**Consultation Response from KC,
Highways Development Management**

2025/91837 104, Gawthorpe Lane, Lepton, Huddersfield, HD5 0NZ

Change of use of dwelling to mixed-use to include residential (use class C3) and commercial storage (use class B8) in connection with a landscaping business

Date Responded: 27/08/2025

104 Gawthorpe Lane, HD5 0NZ

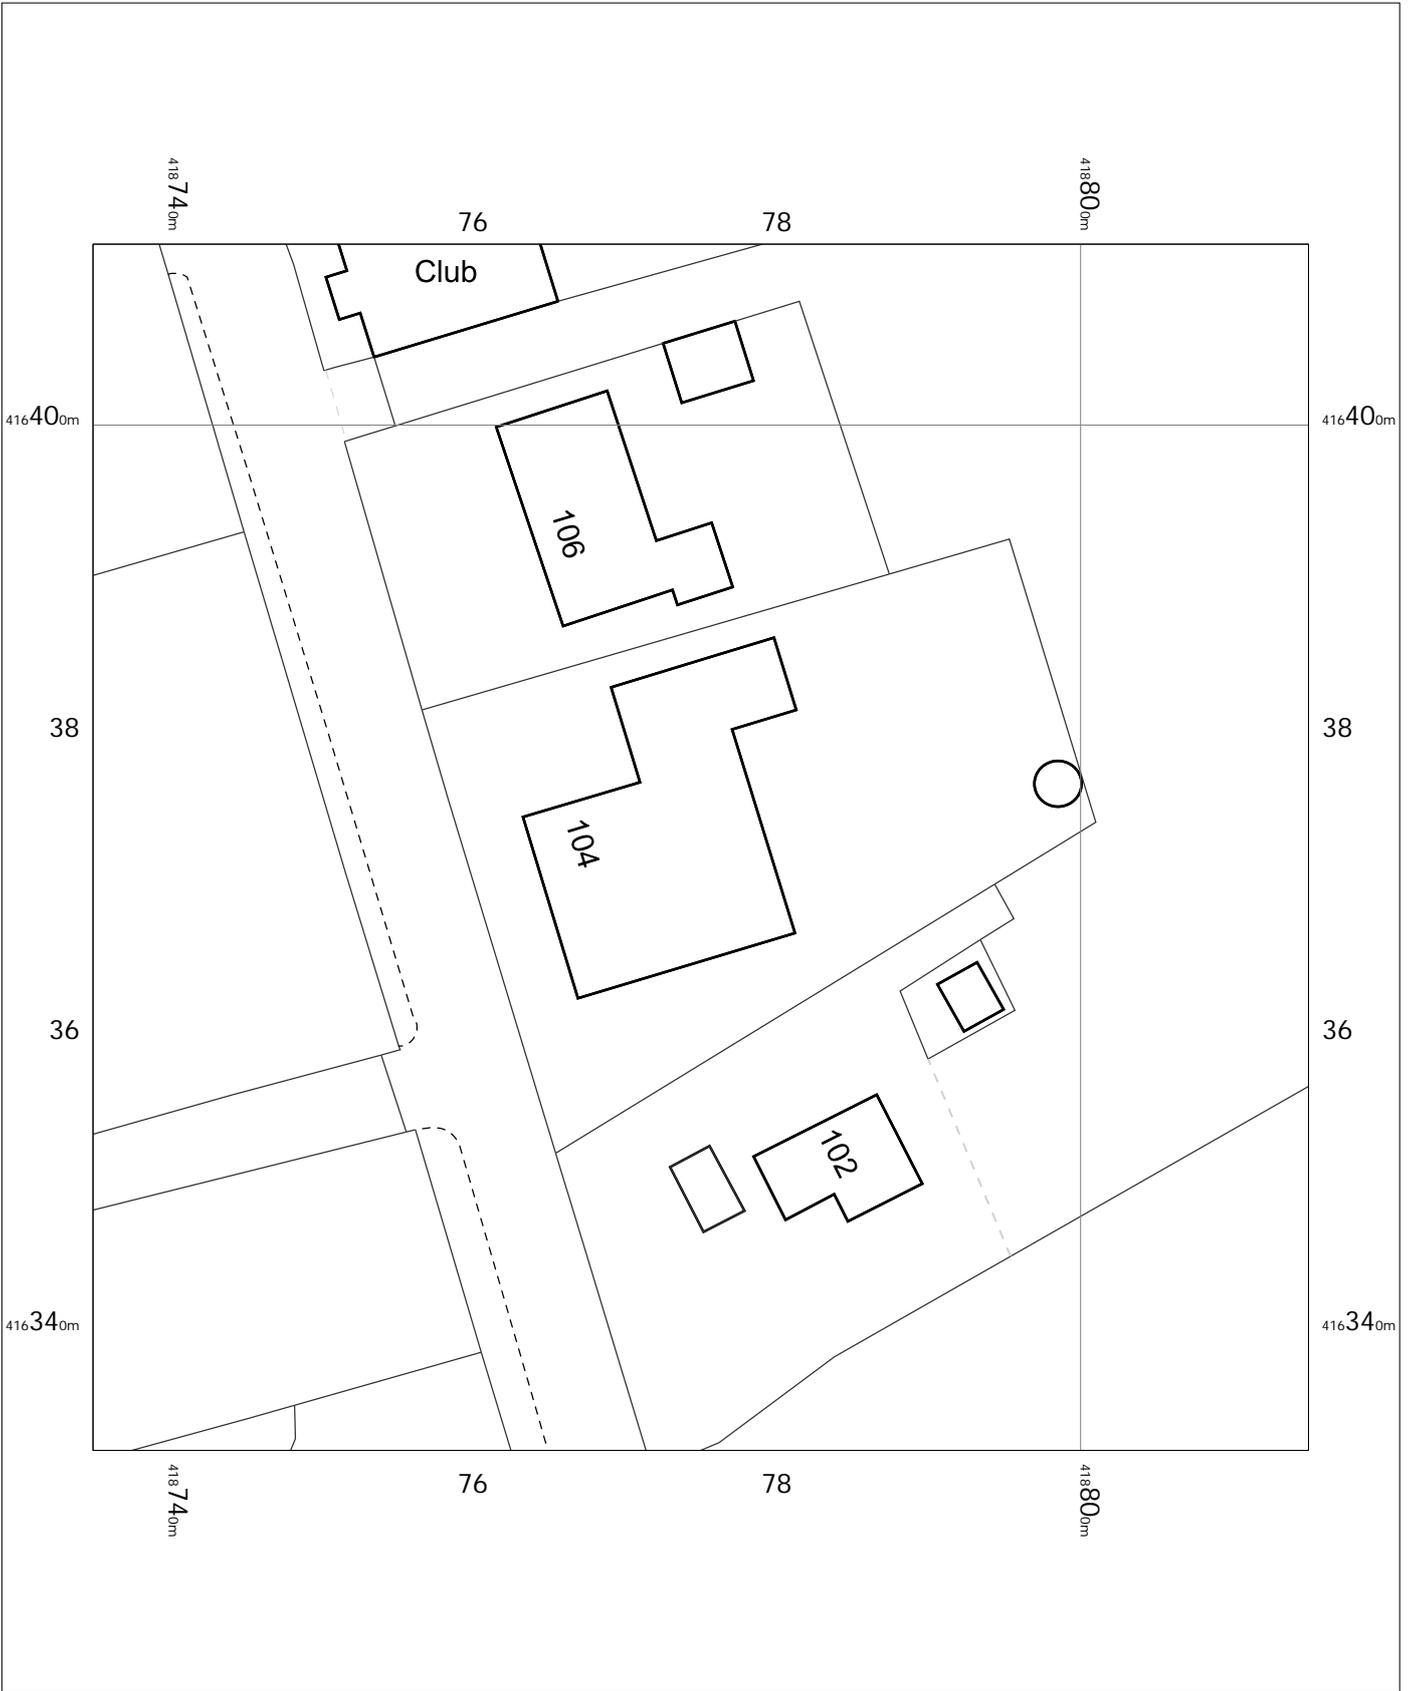
The property has two drives leading on to Gawthorpe Lane and space to accommodate all the vehicles and trailer on the site.

The application is acceptable to Highways D M. However, it appears that this would be the limit that this site could accommodate and any increase could lead to additional vehicles being parked on the highway

As a result, I would request that a condition is imposed restricting the number of vehicles to this limit to prevent any overspill on to the Highway.

The approved vehicle parking areas will need to be surfaced and drained in accordance with the Communities and Local Government; and Environment Agencies 'Guidance on the permeable surfacing of front gardens (parking areas)' published 13th May 2009 (ISBN 9781409804864) as amended or superseded.
